Post Hearing Note following the Open Floor hearing 5th March 2019

Deadline 7 submission

Dafydd Griffiths on behalf of the NACP

Post Hearing Response – Deadline 7
Route of the Lôn Las Copr / Copper Trail
Dafydd Griffiths on behalf of the NACP

Figure 1-1 A5025 Off-line Highway Improvements Overview

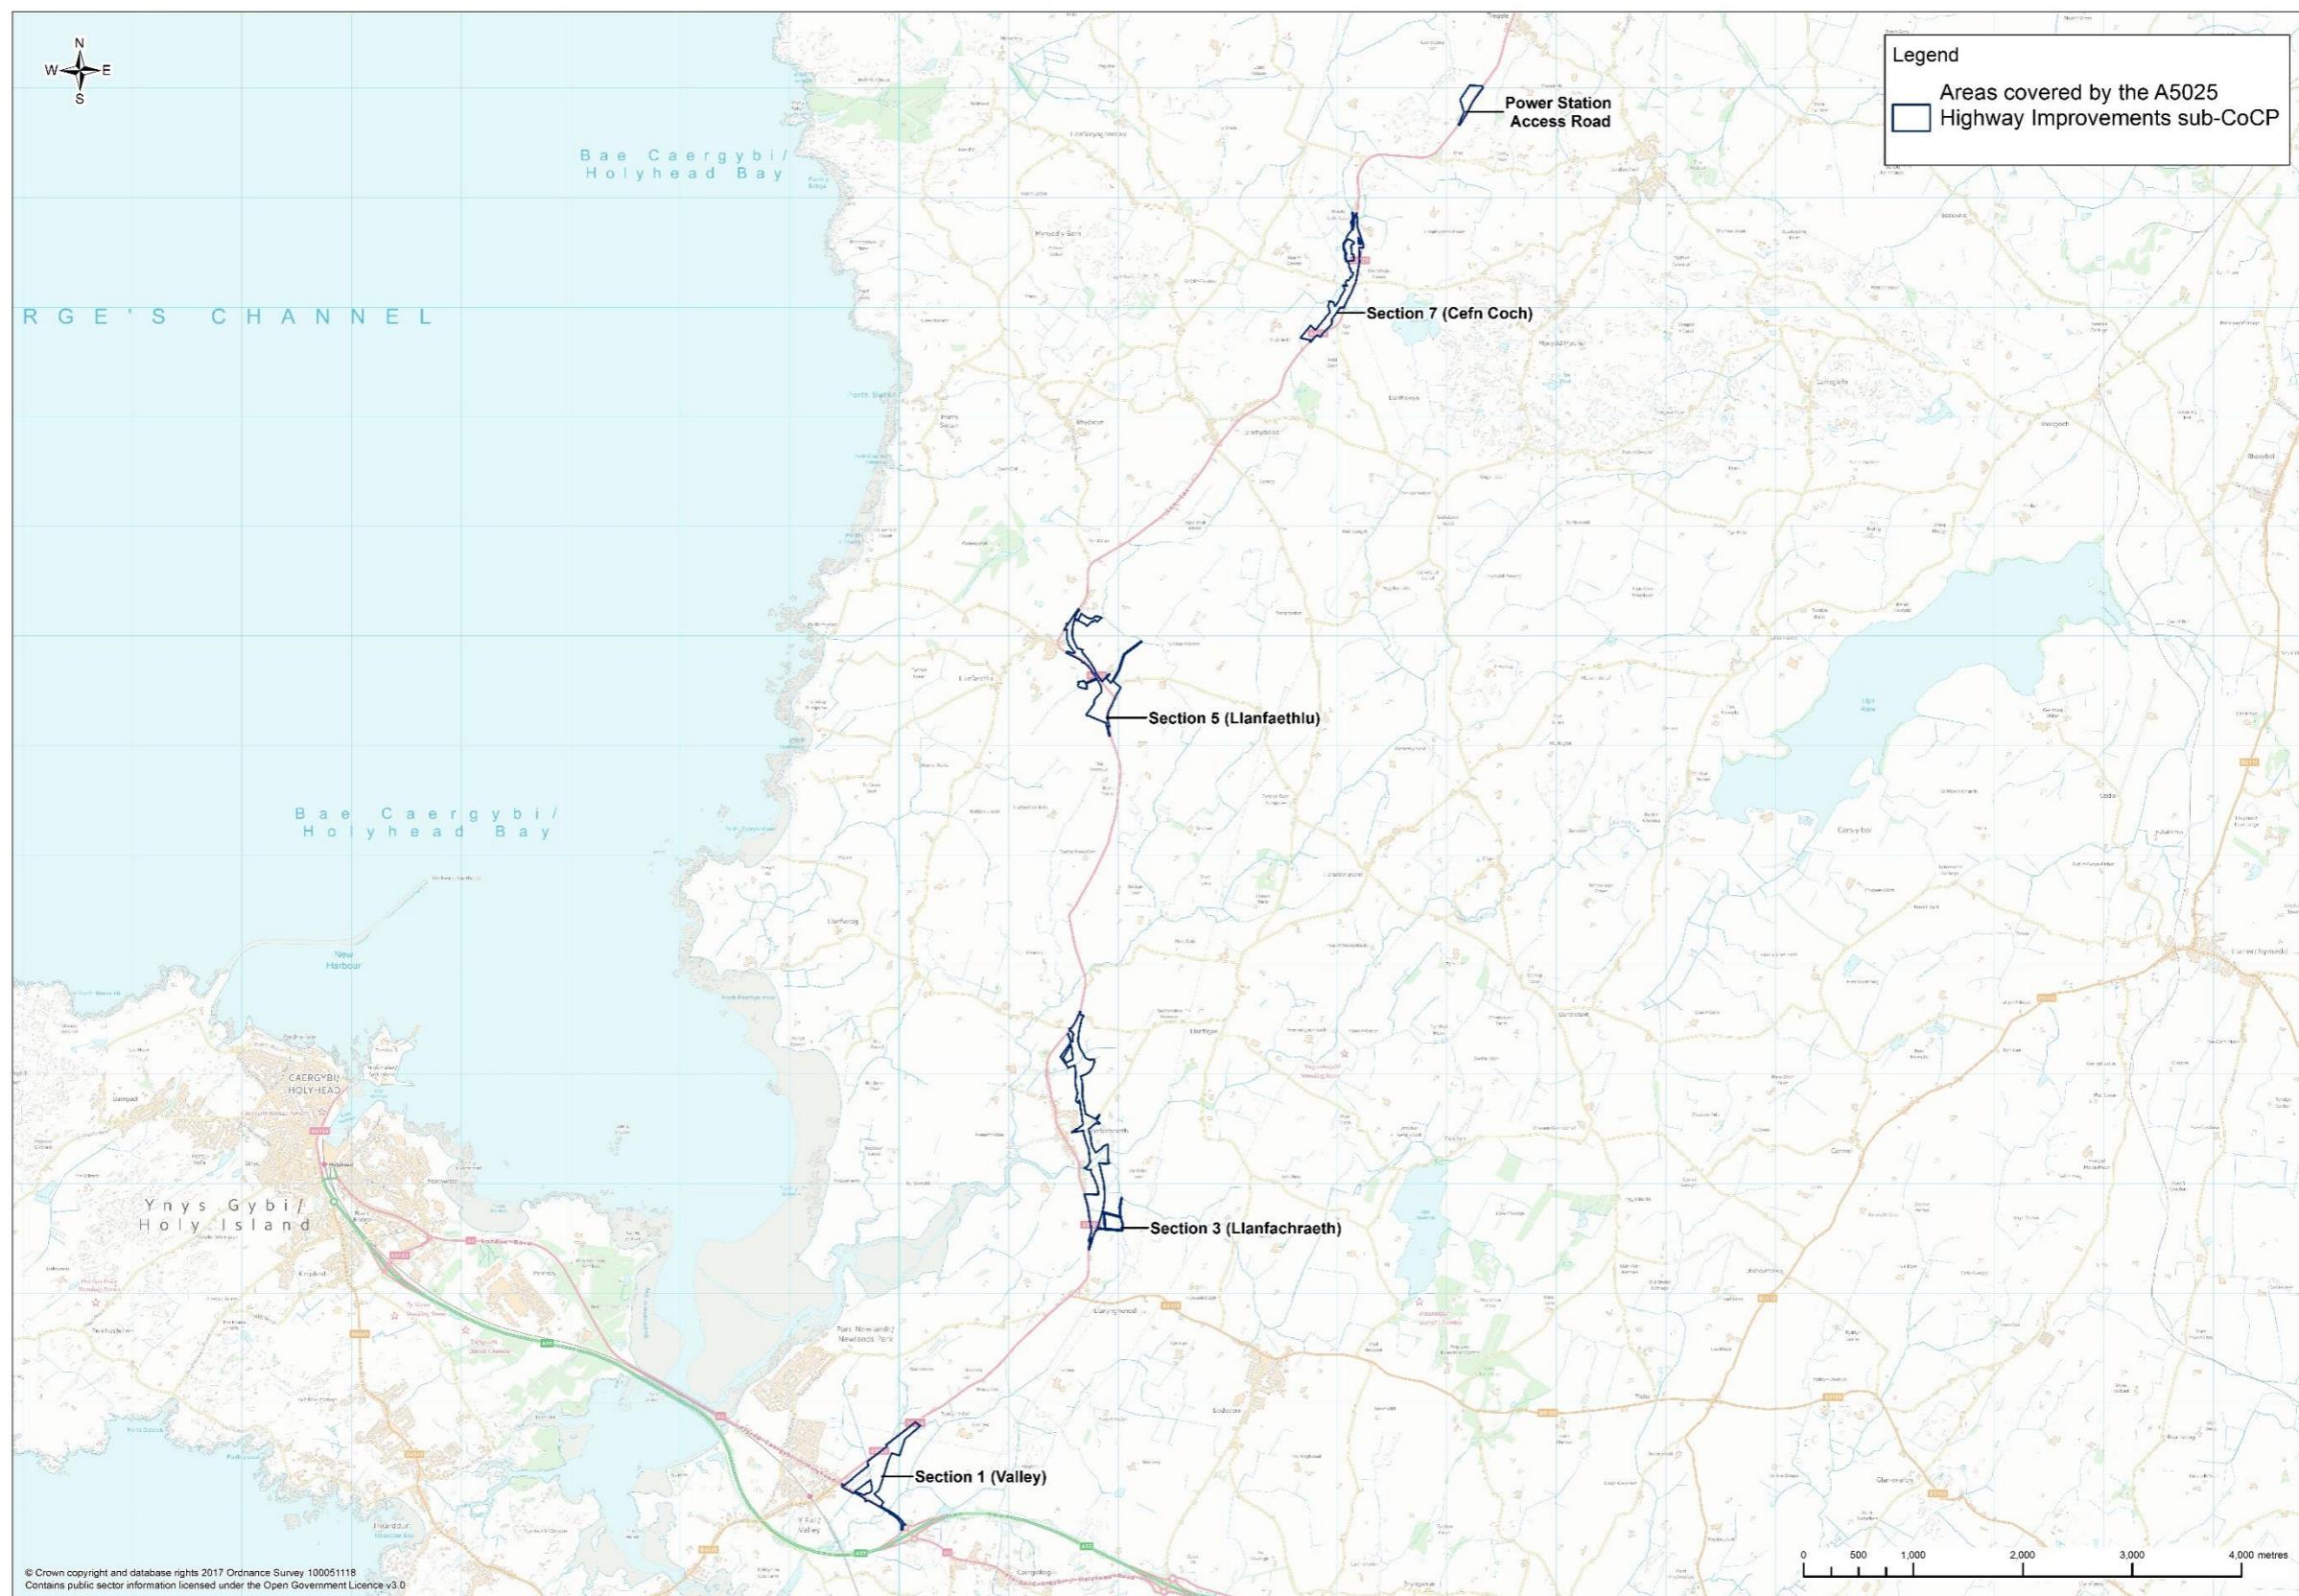
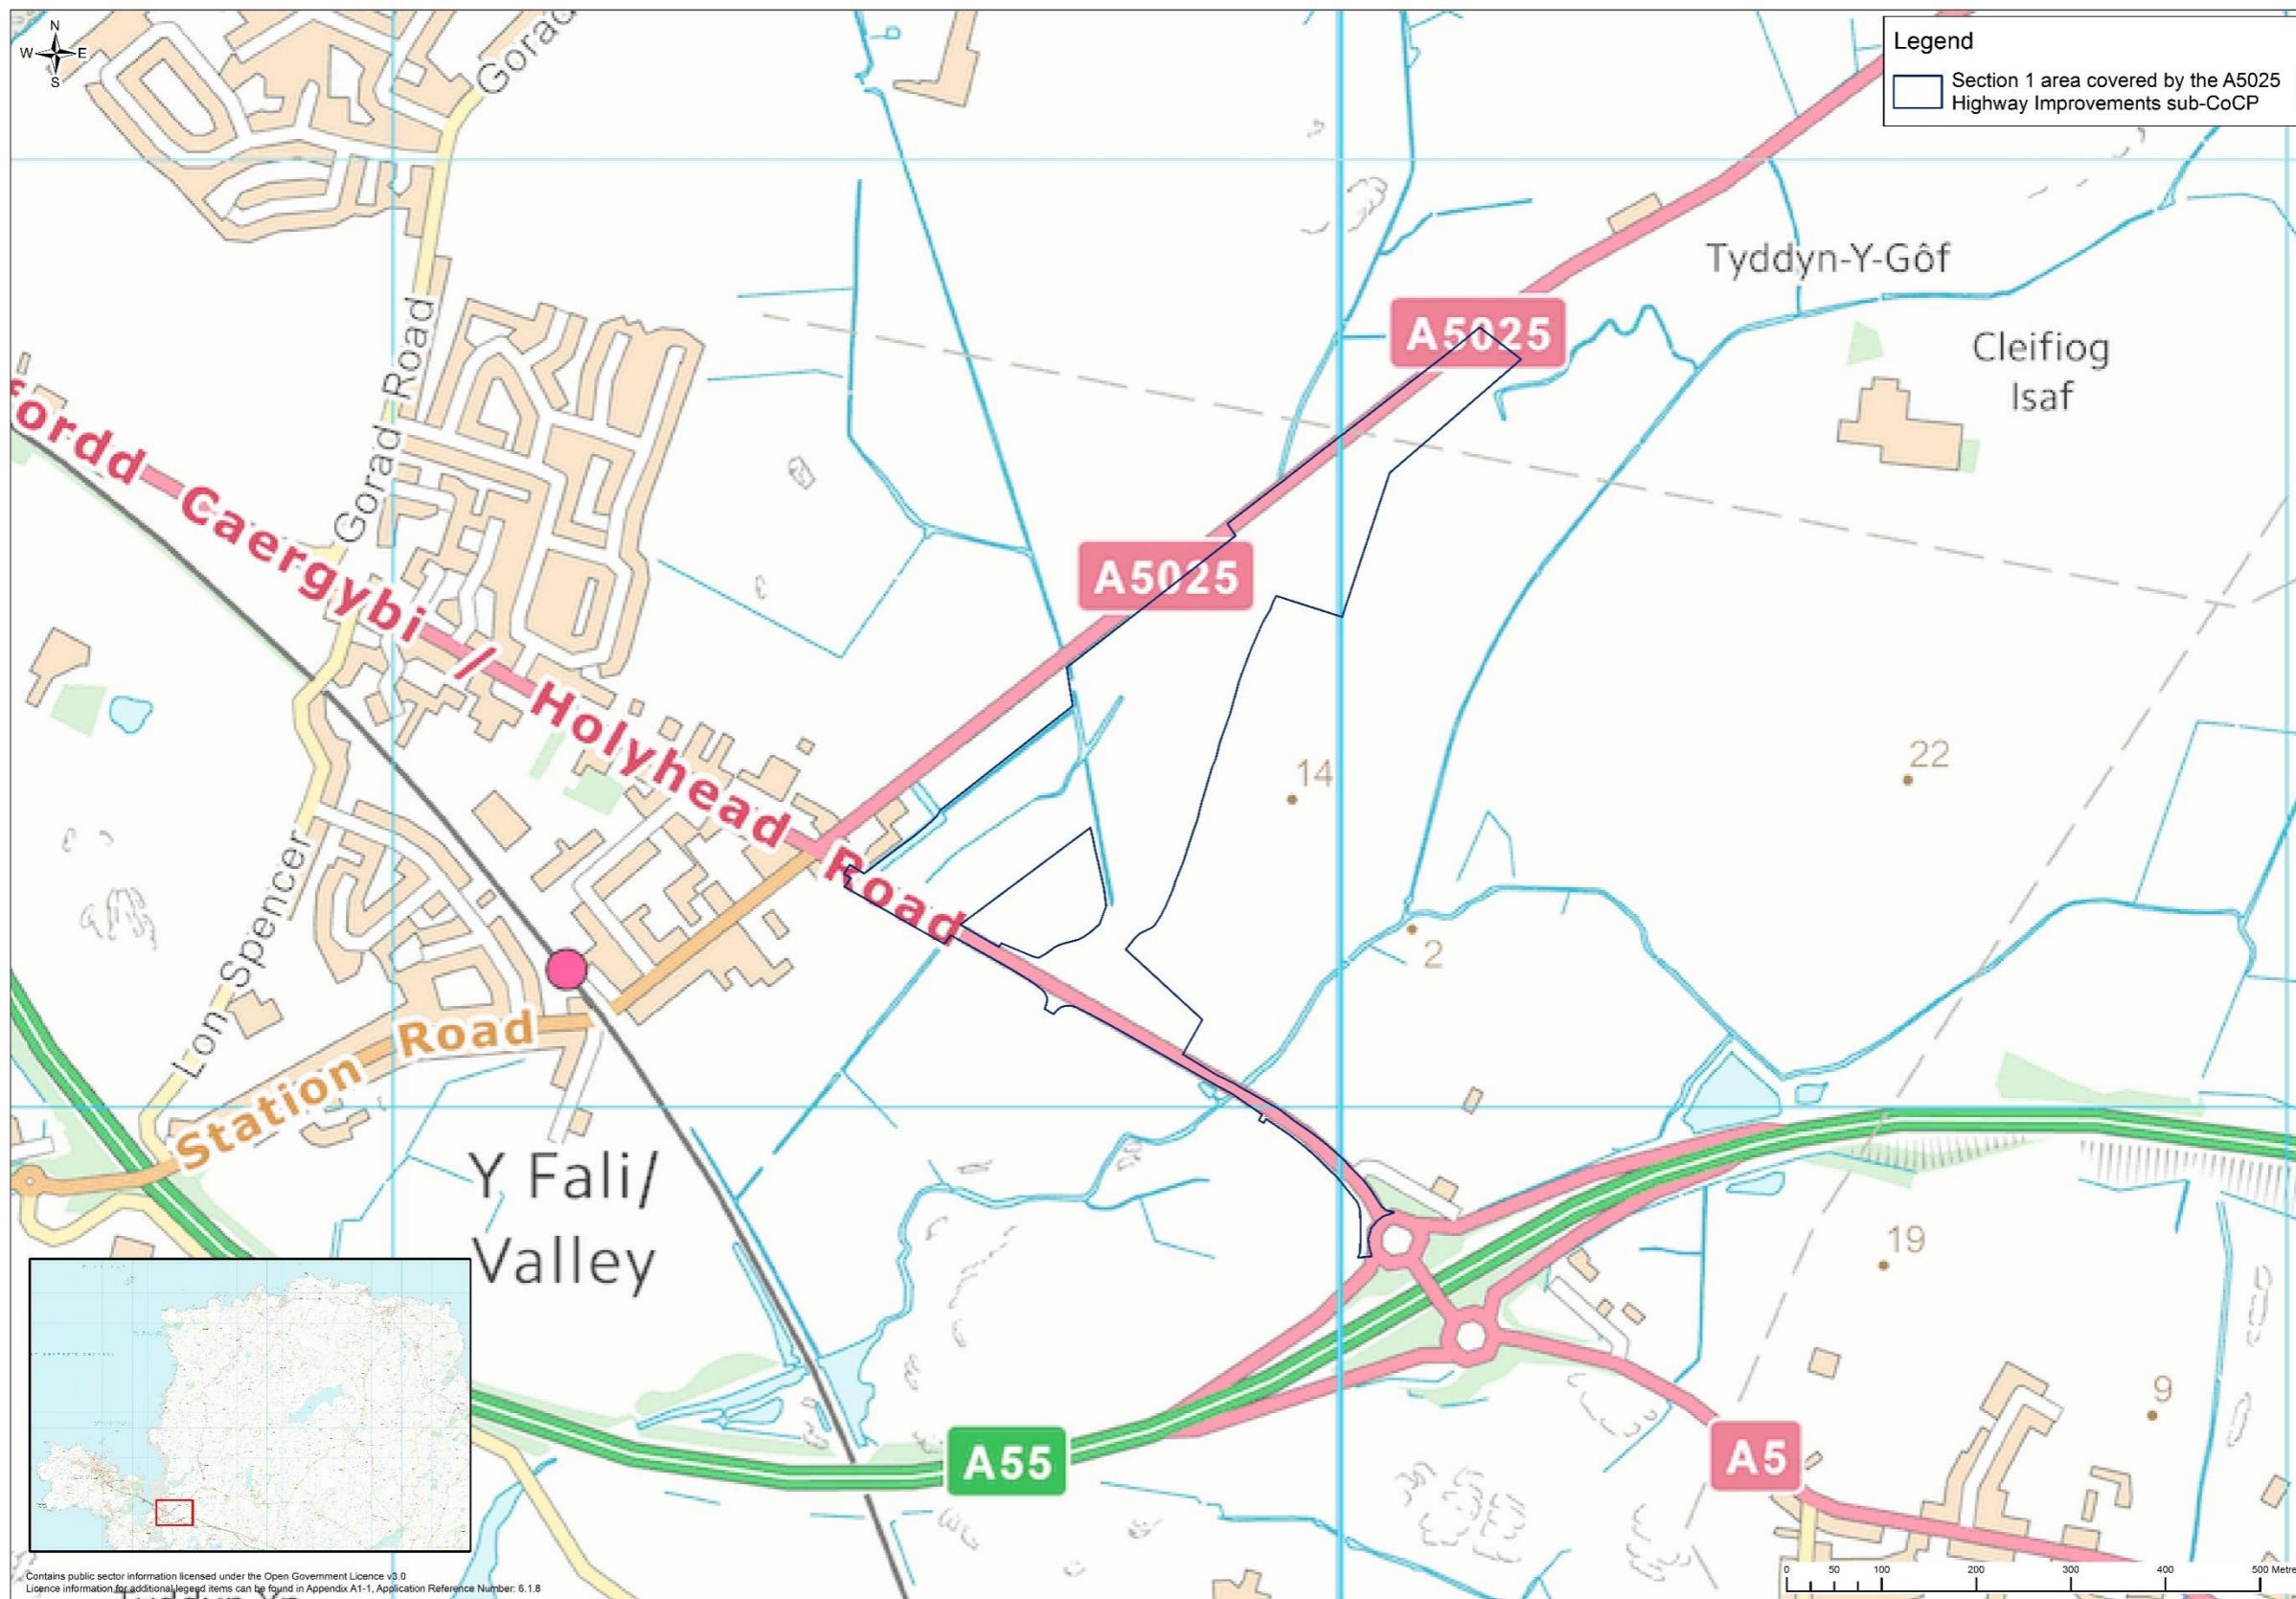
Concerns have been raised during the pre-application process and during the examination at deadline 2, deadline 4 and deadline 6 that improvements proposed on the A5025 between Valley, the WNDA and Cemaes have not given sufficient weight to the impact on Non-motorised Users (NMU).

At deadline 4 the NACP identified specific sections of the A5025 where the applicant was proposing NMU infrastructure but in the opinion of the NACP the proposals were inadequate. The NACP also identified other specific sections of the A5025 where the applicant currently had no NMU infrastructure proposals but where, in NACP's view, mitigation was needed. At deadline 6, as a follow up to the Accompanied Site Inspection that took place on the 14th February 2019, the NACP submitted further comments and proposals on the most appropriate route for the Lôn Las Copr / Copper Trail during both the construction and operational phases of the Wylfa Newydd Power Station.

The NACP are of the view that the Lôn Las Copr / Copper Trail could and should be routed as close to its original route as is possible and desirable during both the construction and operational phases of the Wylfa Newydd project.
